Our ref: XA/2026/100512

Your ref: EN010163

ENVIRONMENT AGENCY DEADLINE 2: STEEPLE RENEWABLES.

RESPONSE TO DOCUMENTS SUBMITTED AT DEADLINE 1 AND RESPONSE TO ExQ1.

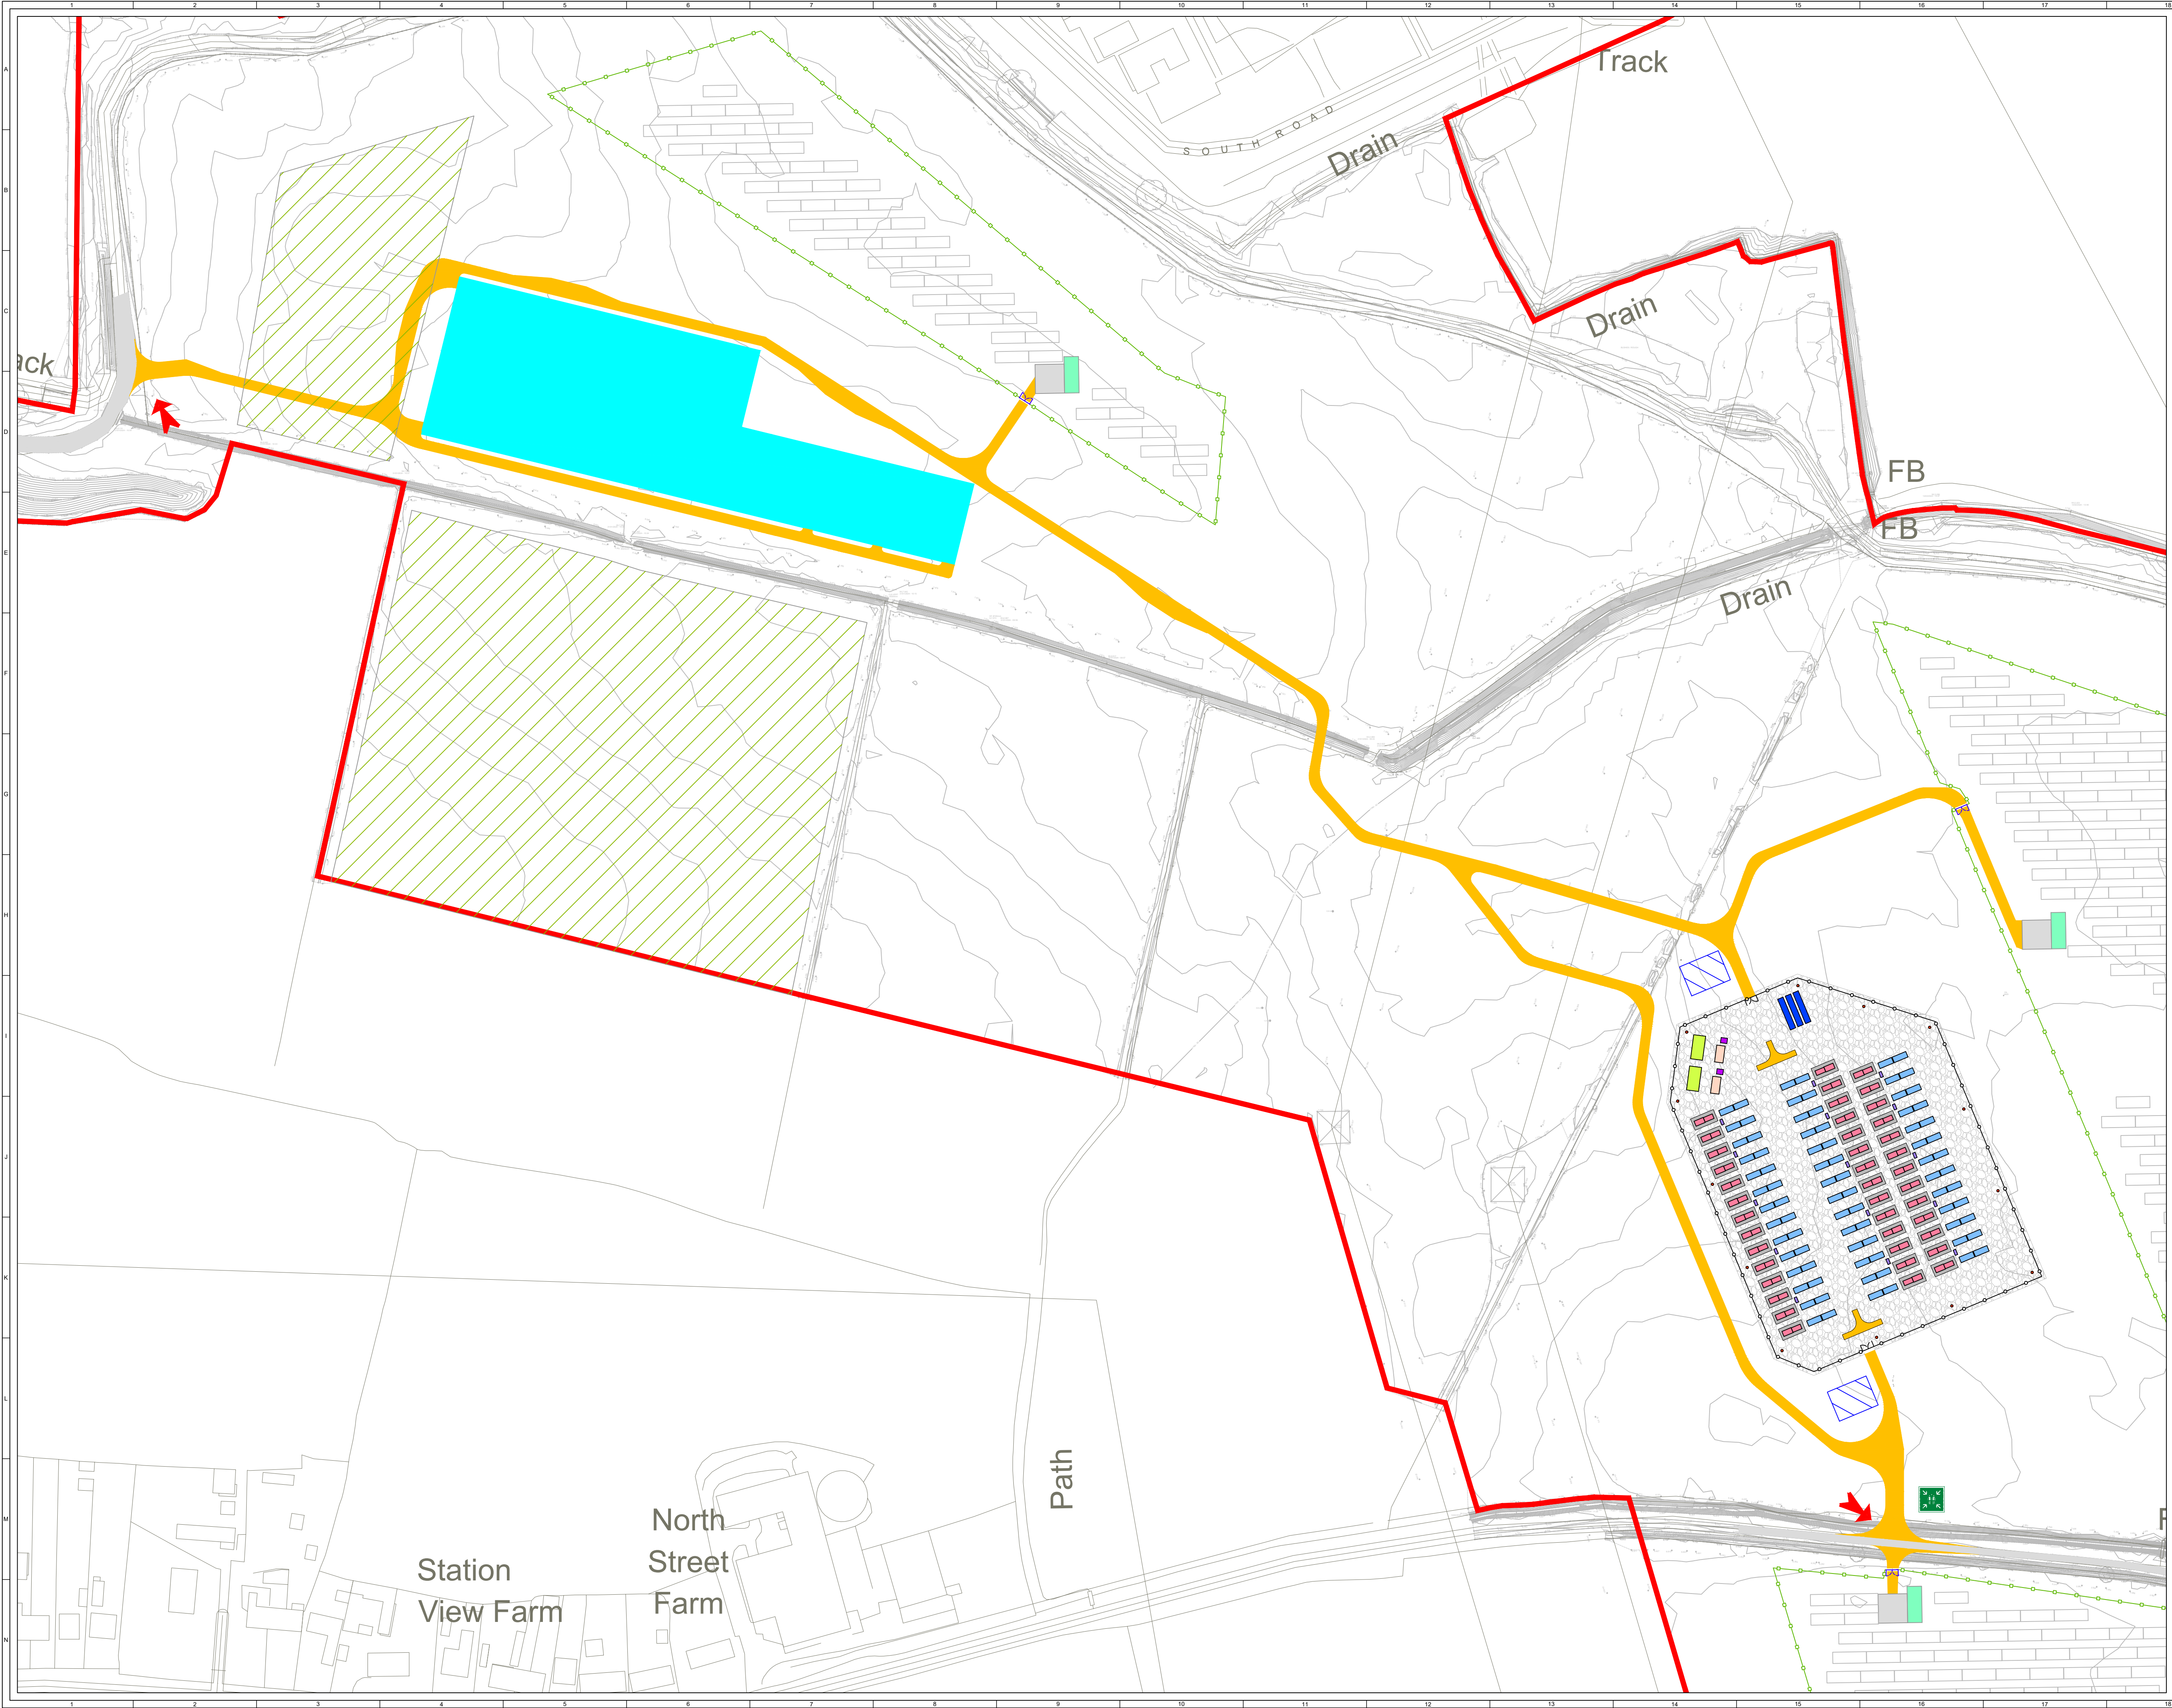
Point for consideration: The Outline Fire Risk Management Layout does not show the proposed drainage basin and automatic closures.

Working on a solution. We are pleased to see that the relevant plan and other deliverables will be updated, and we look forward to seeing these in due course.

Our comment:

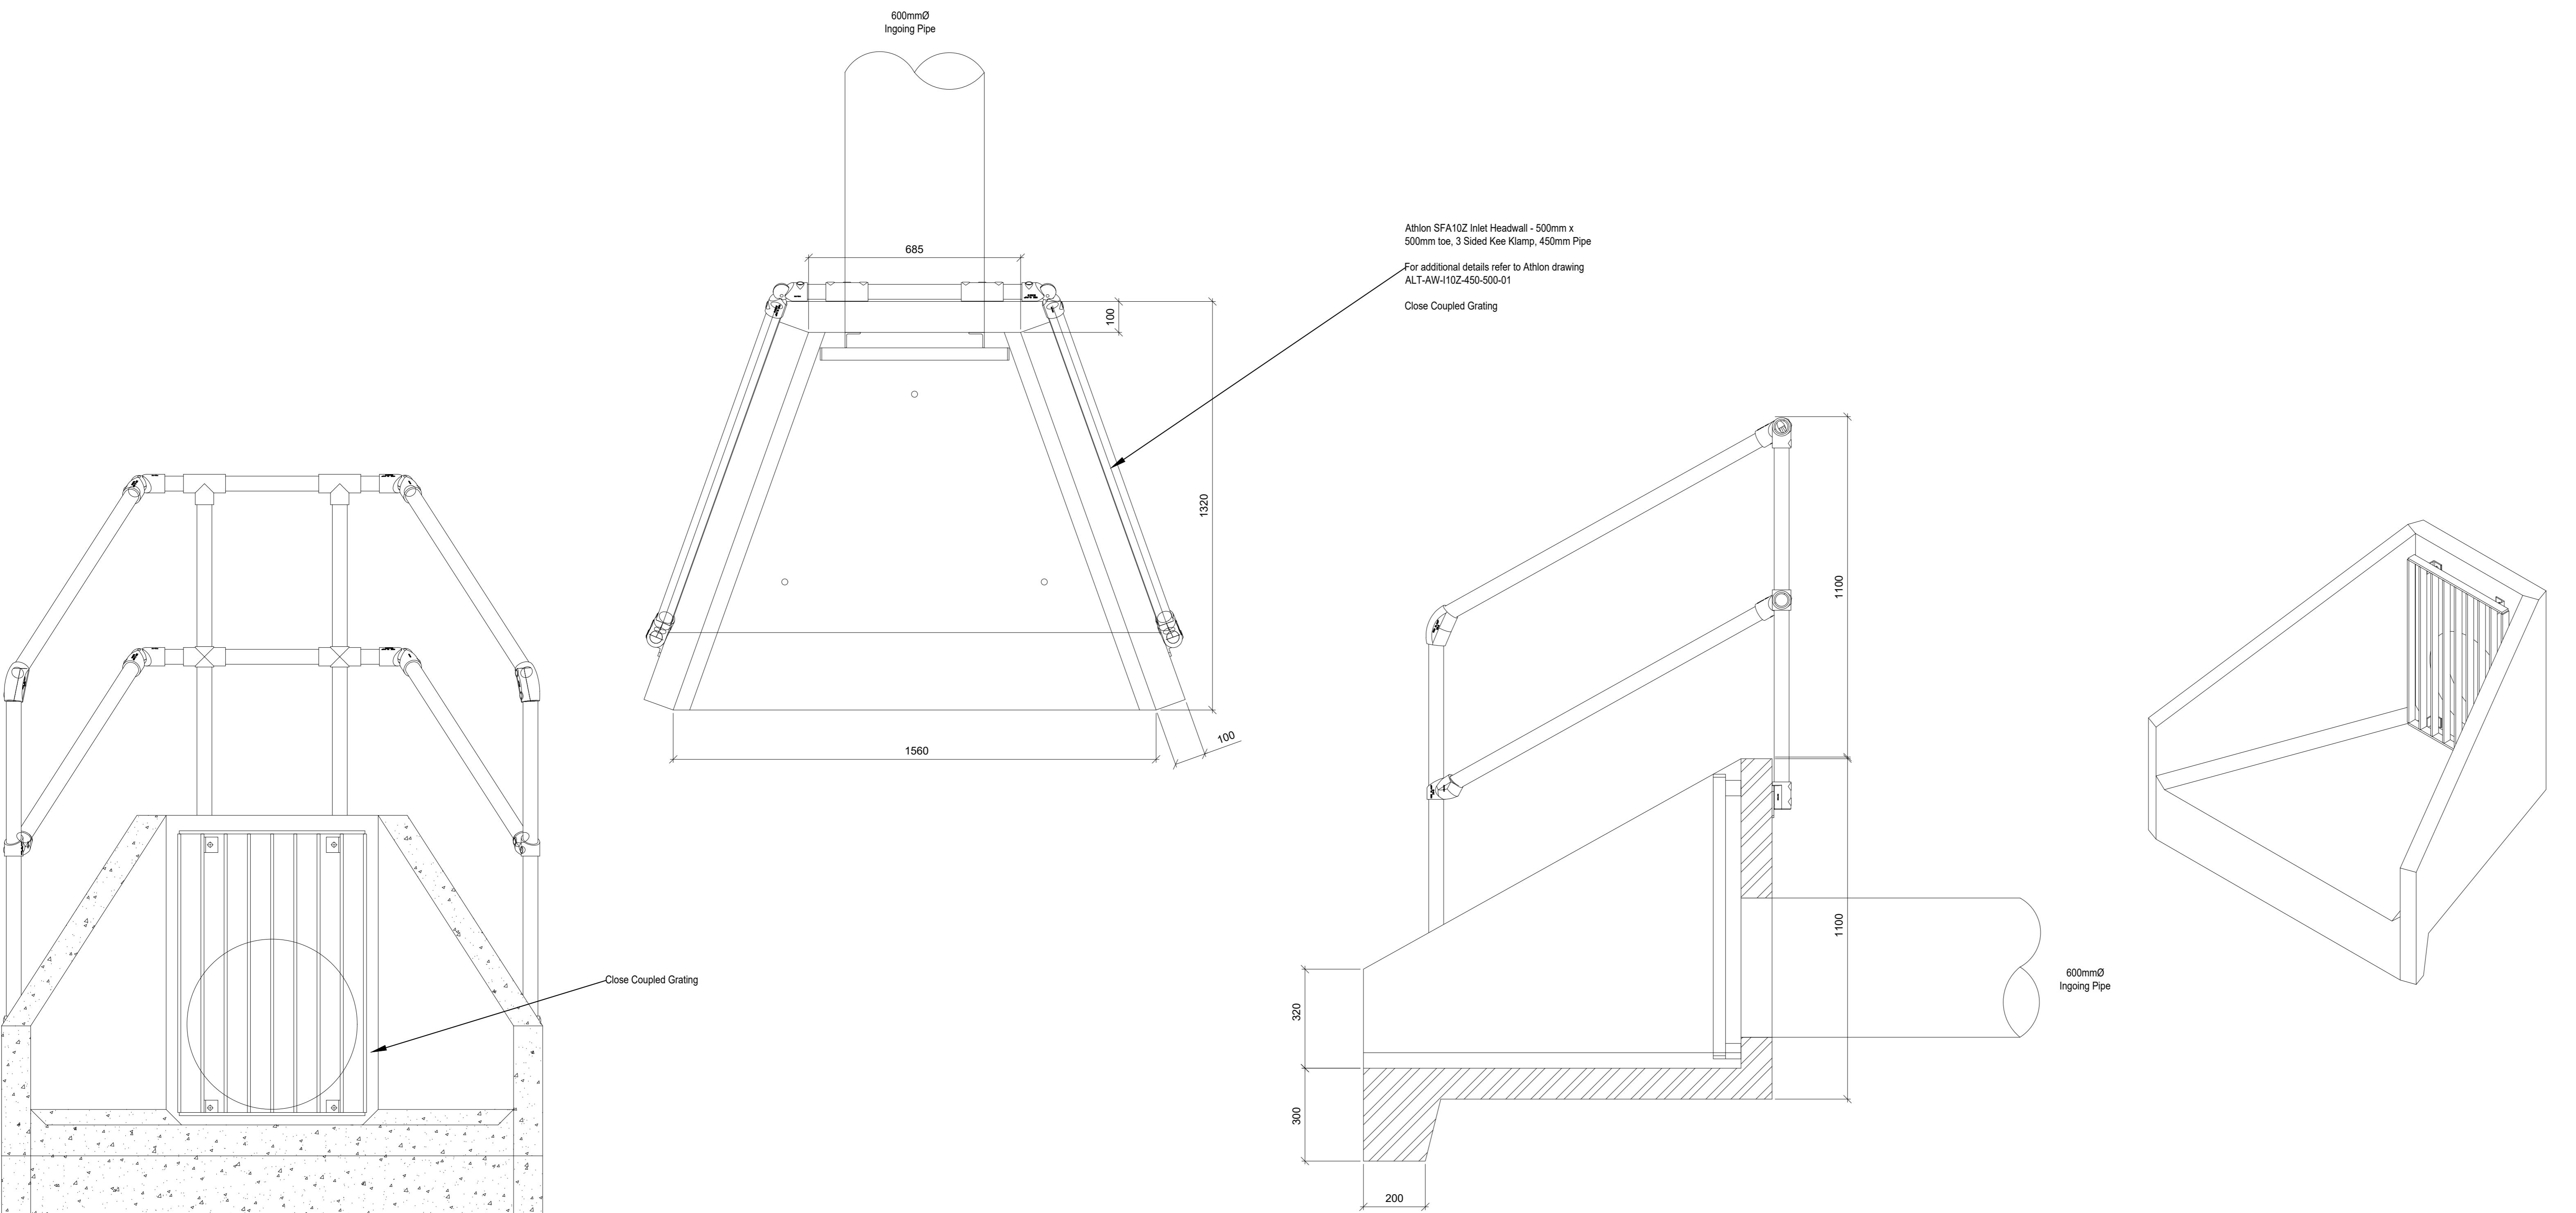
GWCL6 Proposal for drainage systems around BESS sites to be infilled with gravel.

Working on a solution. We are pleased to see that further information will be provided, and we look forward to seeing this in due course.
